Recommendation Report for Planning Permission for Works or Extension to a Dwelling

REF NO: A/105/22/HH

LOCATION: 14 Merryfield Crescent
Angmering
BN16 4DA

PROPOSAL: Single Storey Front infill Extension.

EXISTING ROOF PLAN

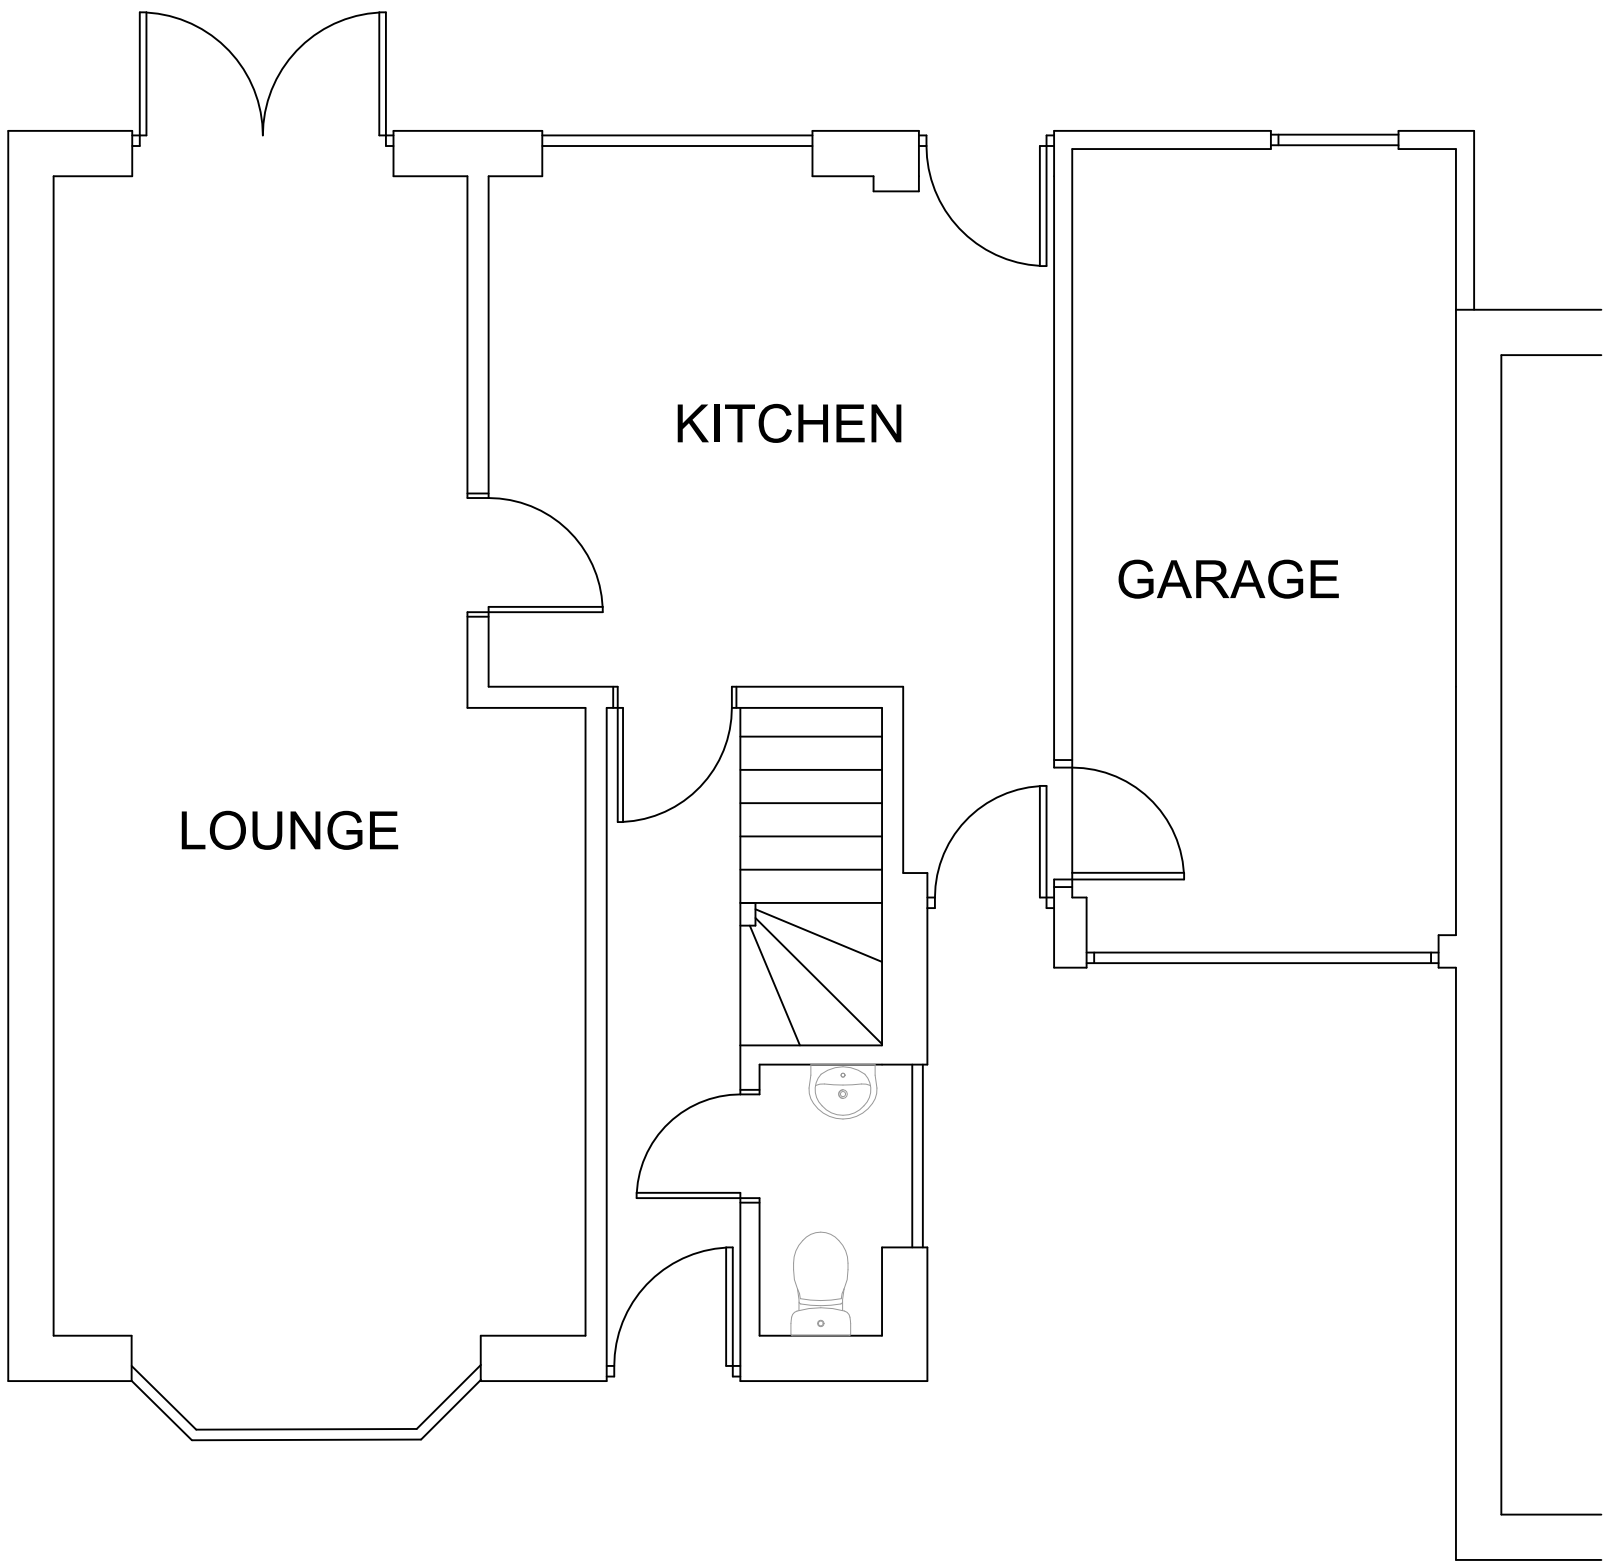
The extension is approx. 2.7m in depth, 3.5m in width, and reach a peak height of approx. 3.7m with eaves at 2.4m. There is to be a pitched roof design which would rise to meet the underside of the first floor front window made interlocking tiles. The scale of the proposed extension is minor, remaining visually subservient to the host dwelling. There is to be cement board cladding introduced to the front elevation of the extension. Cladding is not dominant but not an uncommon feature within the area and is similar to the commonly seen shiplap boarding. However, to ensure the colorations and finishes reflect local vernacular, a condition is recommended requiring a submission of these details.

The scale and siting of the proposal are such that it would project up to the existing front elevation of the property, not exceeding the forward most building line in accordance with Section M of the Arun Design Guide. The terrace in which the dwelling is situated, consists of 7 No. dwellings of similar design, five of which feature recessed attached garages. In constructing this extension, the recessed garage form would be lost and as such, this semi-regular design within the terrace would be hindered. However, the extension would remain at single storey and would not result in a complete loss of the staggered form design and so would preserve the single storey design. Additionally, the street features a variety of differing housing designs and there is an example of a similar extension a short distance North on a connecting road (Beech View). Although the proposal would result in a visual alteration to the street scene, it is not a significantly adverse alteration and is not grounds for refusal.

The siting and scale of the proposal is such that it would not intersect any 45-degree sightlines or light accessibility lines as illustrated by Section M of the Arun Design Guide. Furthermore, there will be no new viewpoints. There will be no adverse impacts by way of overbearing, overshadowing, or overlooking.

The extended garage will be connected to the wall of the adjoining property No. 12 Merryfield Crescent thereby minimising any adverse residential amenity impact on the adjoining property. However, the connecting space is an extension of the existing garage and is not habitable space.

- 3 No development above damp proof course (DPC) level shall take place unless and until a schedule of materials and finishes to be used for external walls (and roofs) of the proposed extension have been submitted to and approved by the Local Planning Authority and the materials so approved shall be used in the construction of the extension.
